Rezoning Transportation Analysis

Petition Number: 2021-086

Date	Description
08-02-2021	First Review (DBS)

DEVELOPMENT STANDARDS

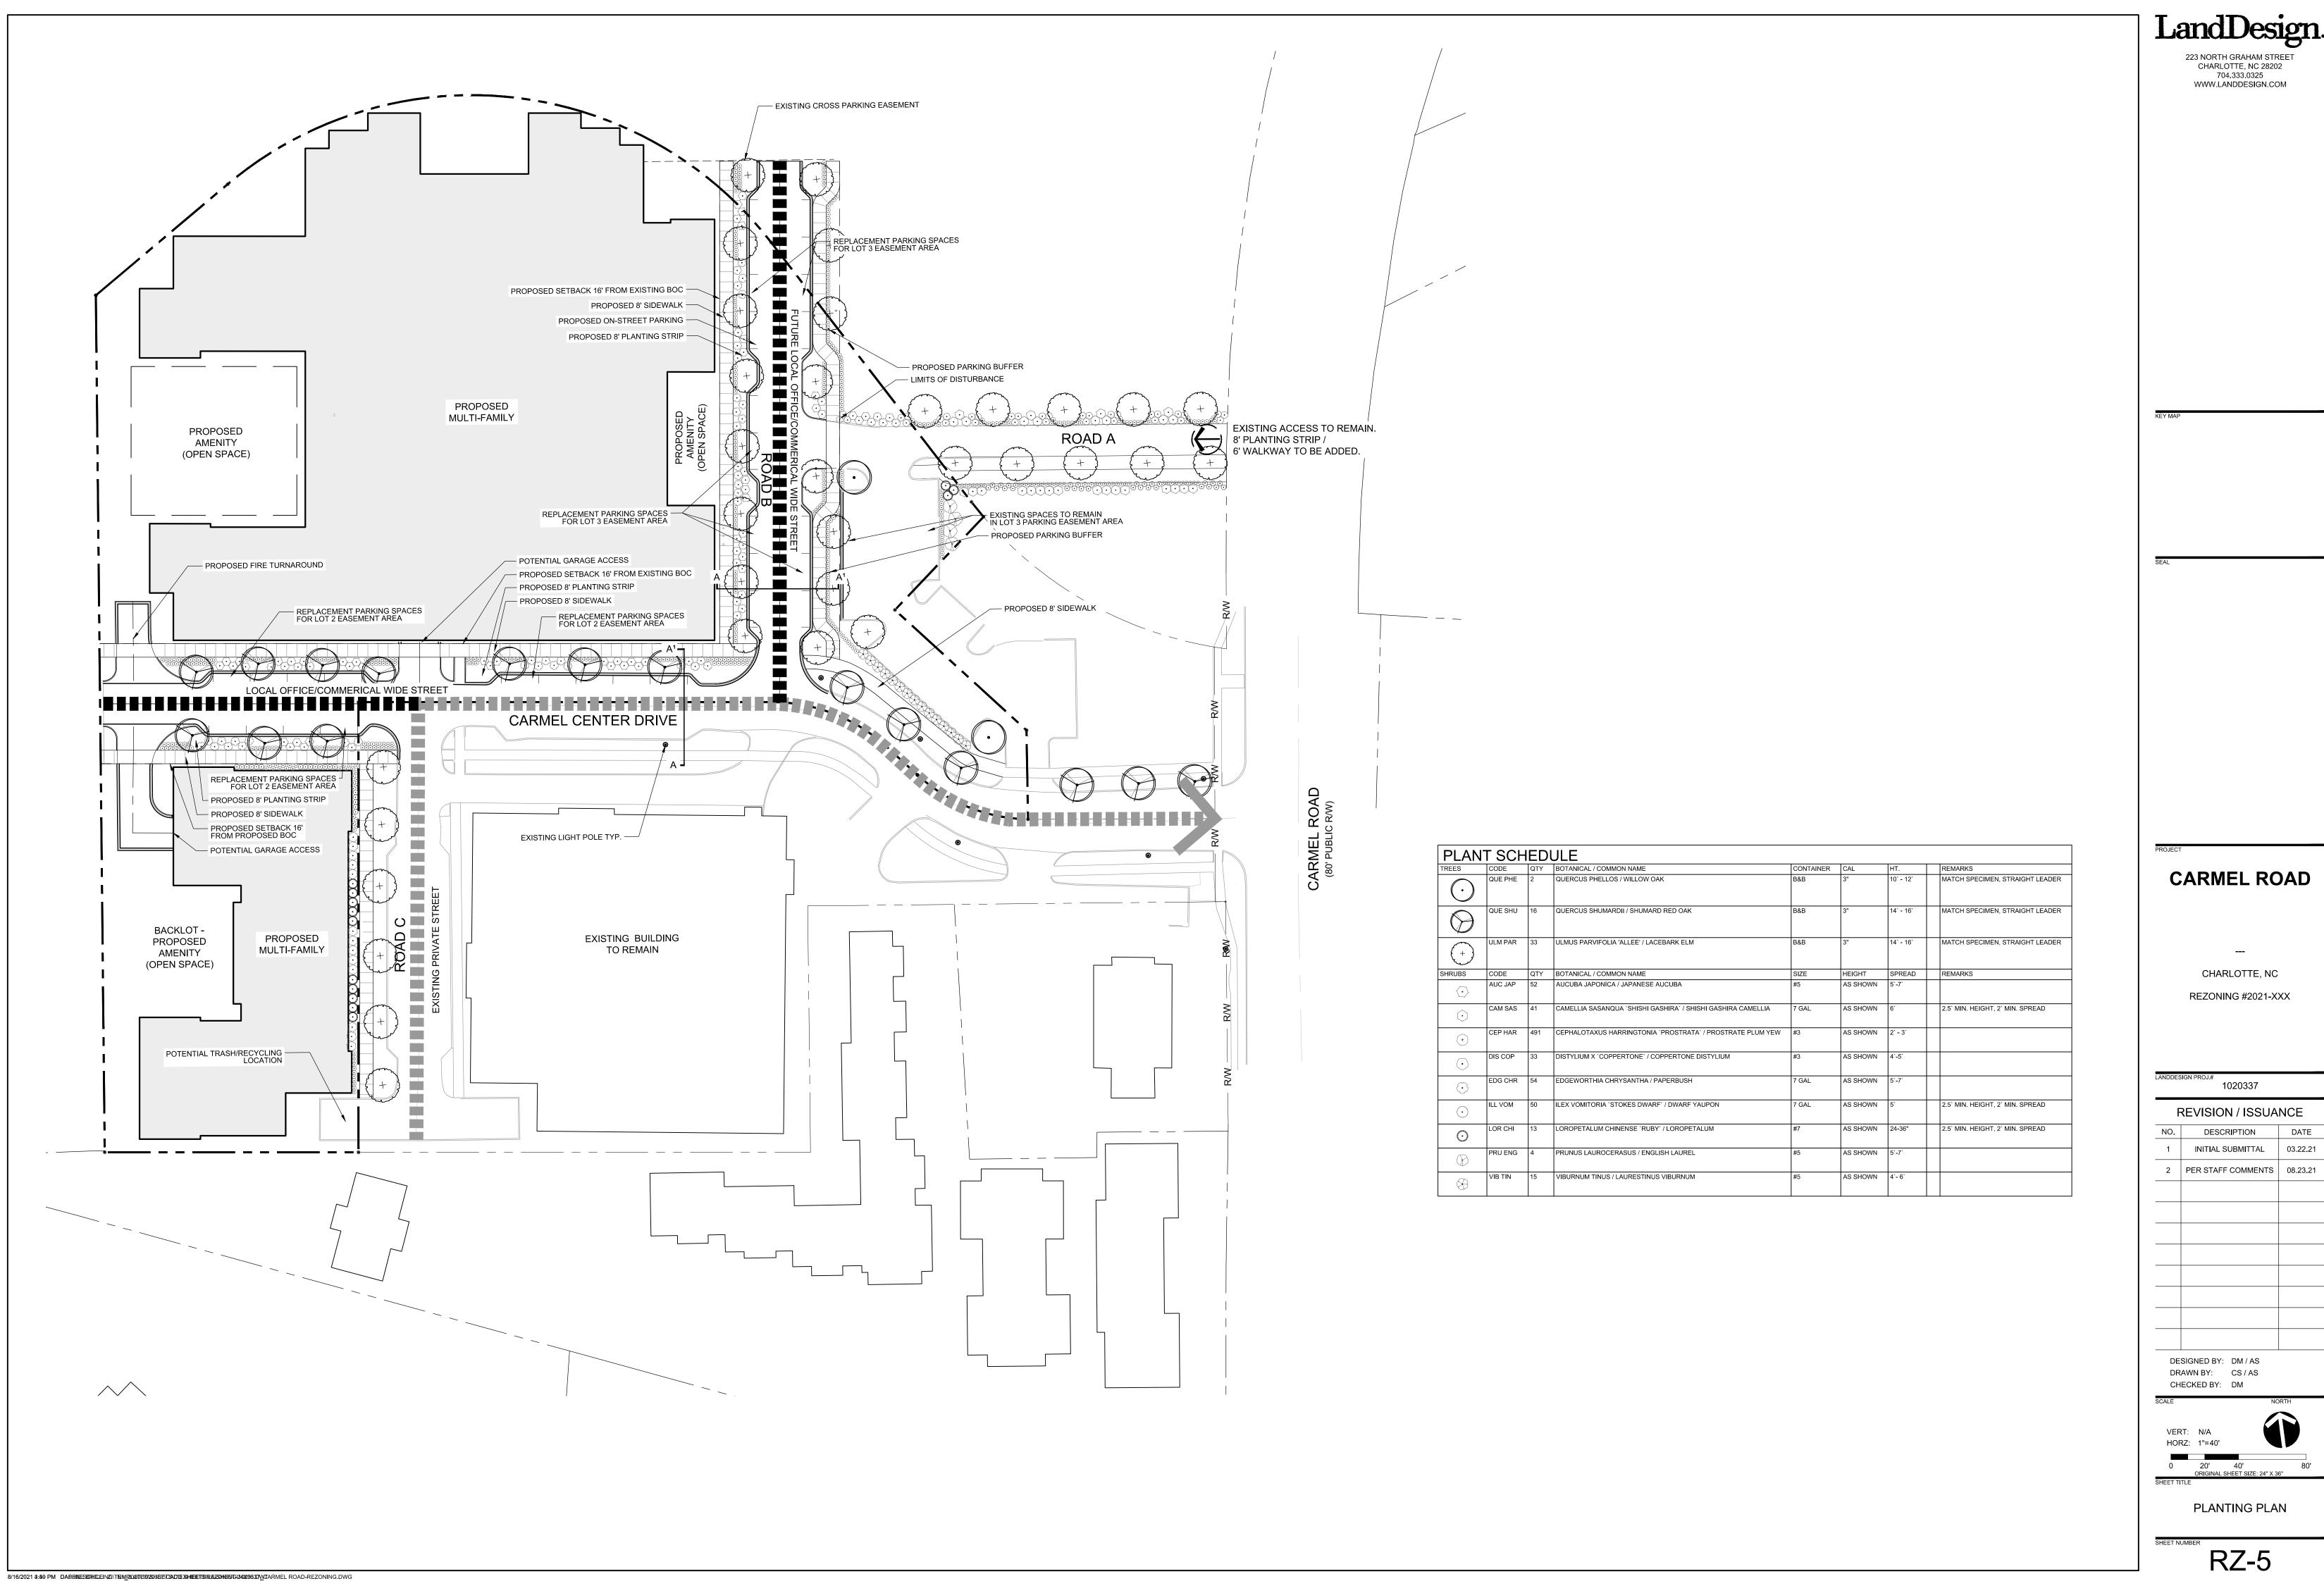
1. A Traffic Impact Study (TIS) is not necessary for the complete review of this petition due to the site generating less than 2,500 daily trips. If during the permitting process the site generates more than 2,500 daily trips, then a traffic study will be required.
2. Site plan and conditional note(s) revisions are needed to clarify that the transportation requirements approved in RZ-2017-021 are still in force and that off-site parking requirements cannot be met by on-street parking spaces.
